DOC20/935057

Senders ref: SSD 10382 (City of Sydney)

Subject: Notice of Exhibition – Student Accommodation, at 90-102 Regent Street, Redfern (SSD 10382)

RETAIL FLOOR AT RL 25.95

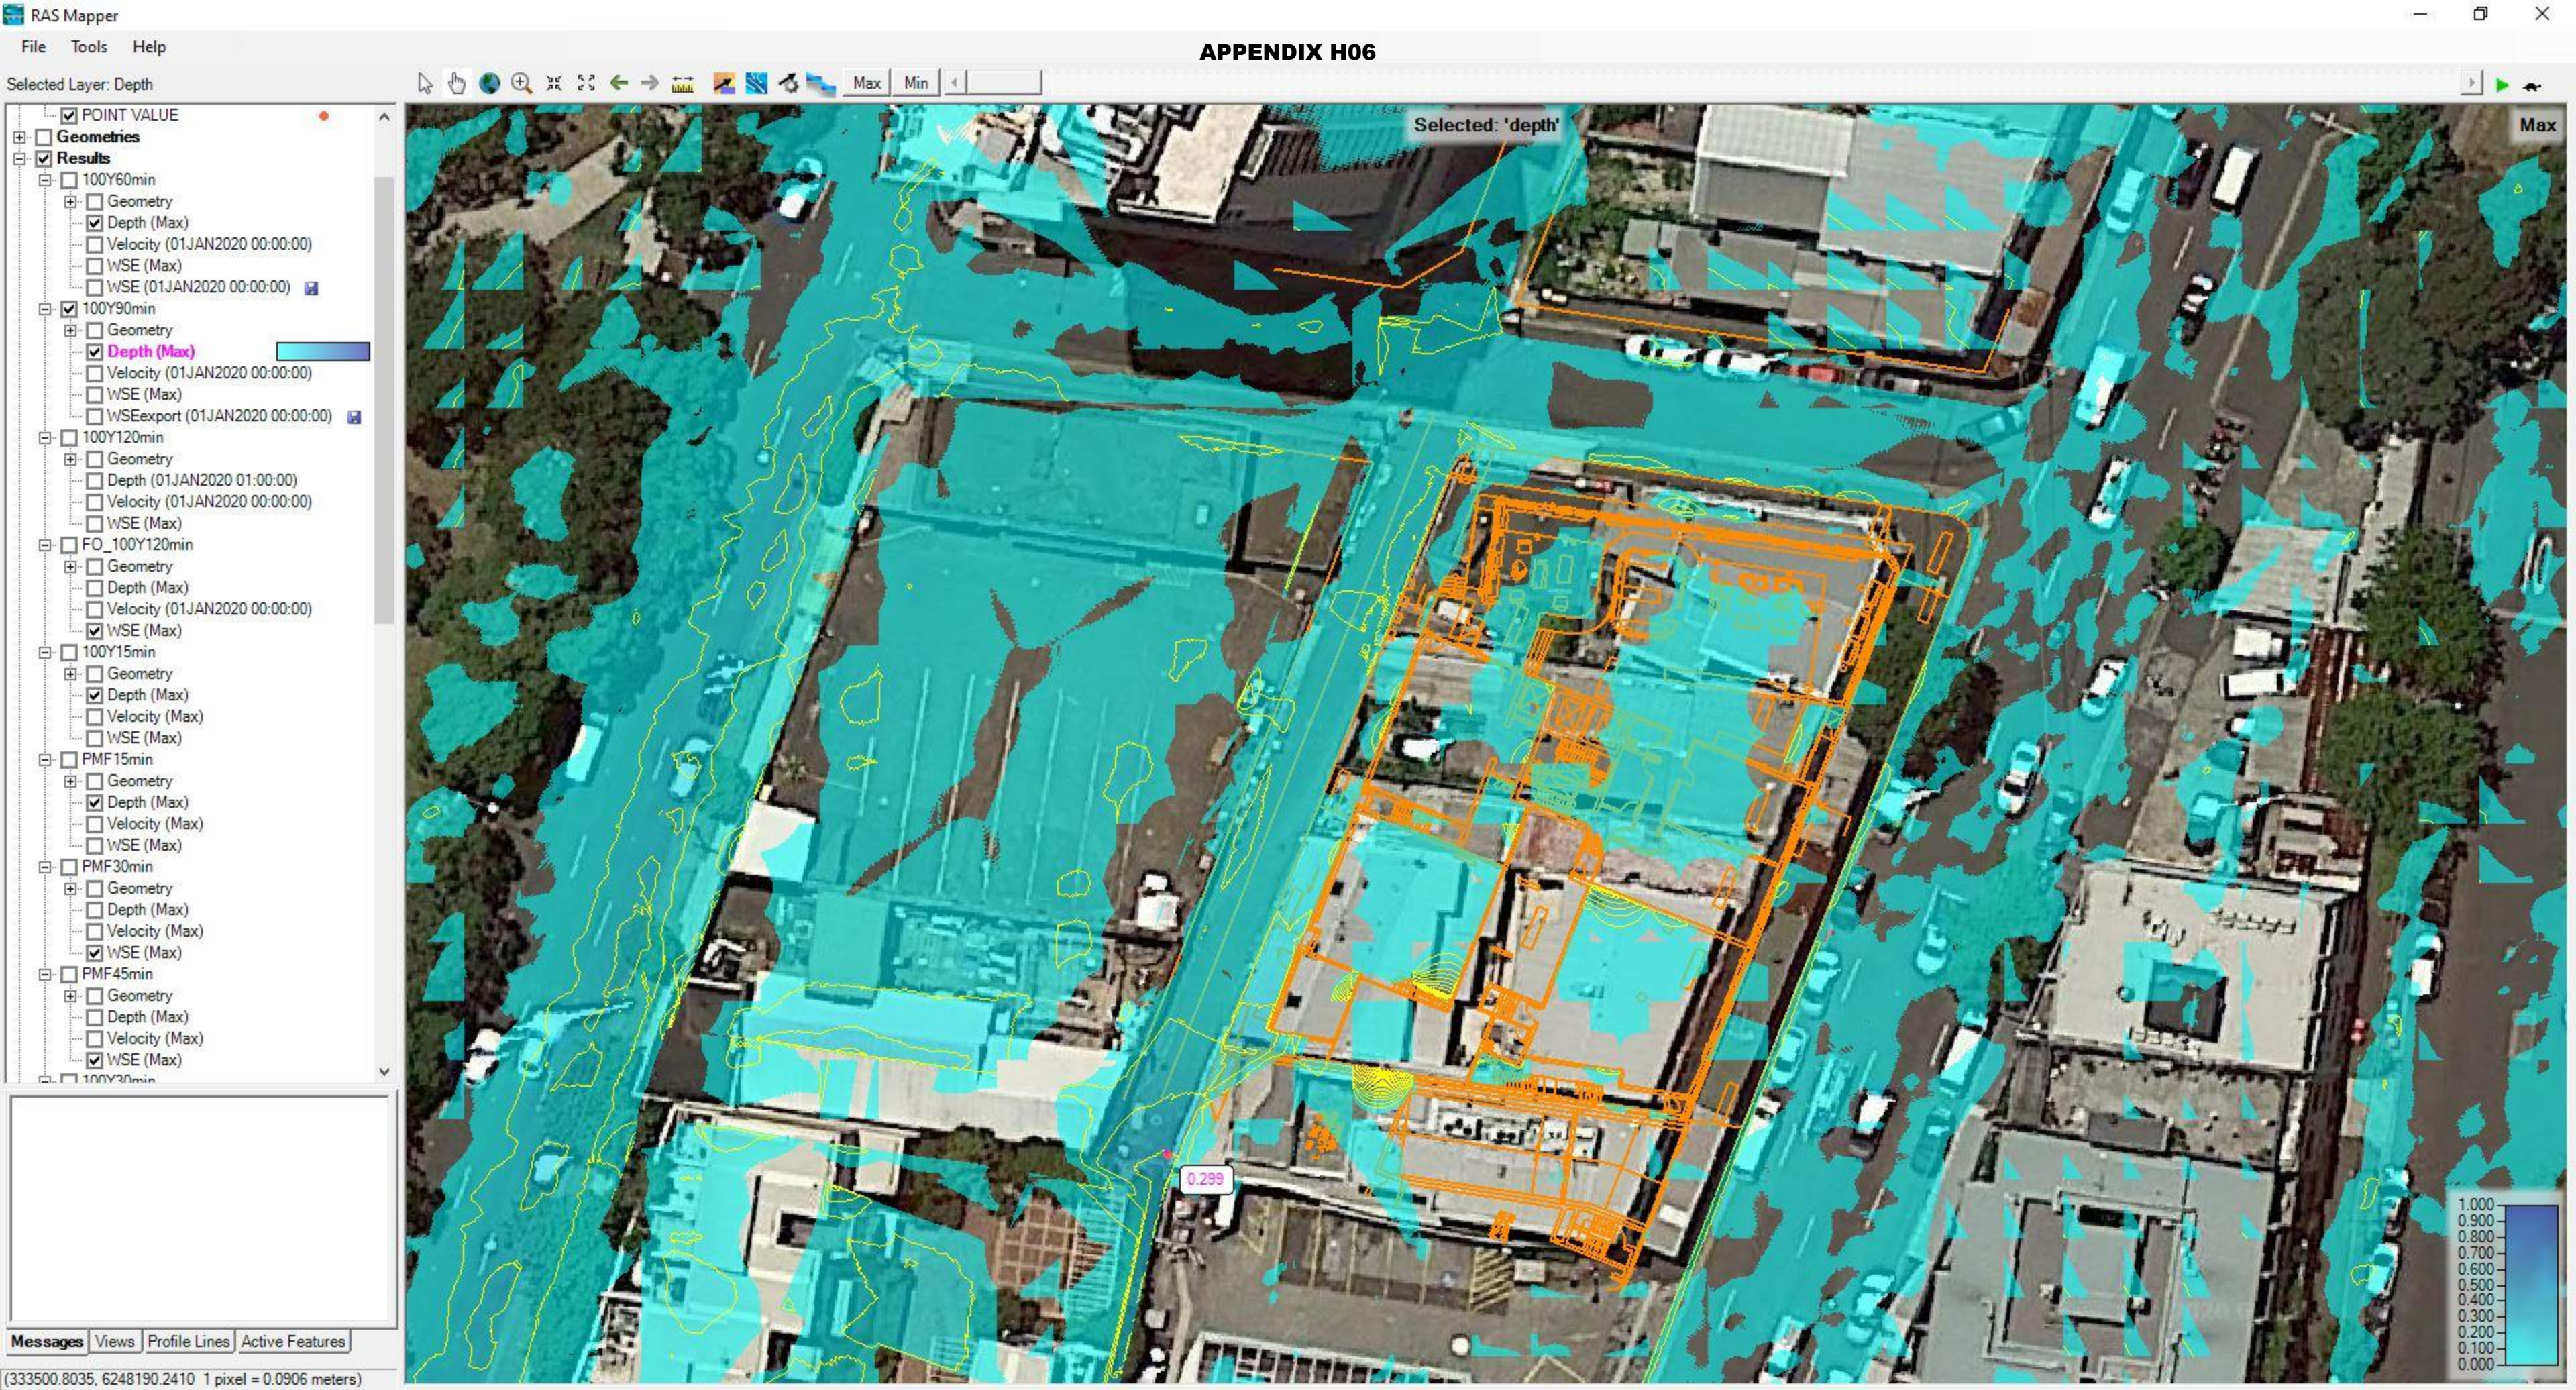
Flood planning levels have been provided, but it is unclear whether these are based on pre or post development modelling. Clarification is required. As stated above, the post development flood information cannot be used at this point. The proposed building includes a basement for bicycle storage, which requires all entry points to be above the 1% AEP flood level plus 500 mm freeboard and the PMF level. The PMF levels have not been calculated and are required for this assessment. EES notes that this requirement has not been met.
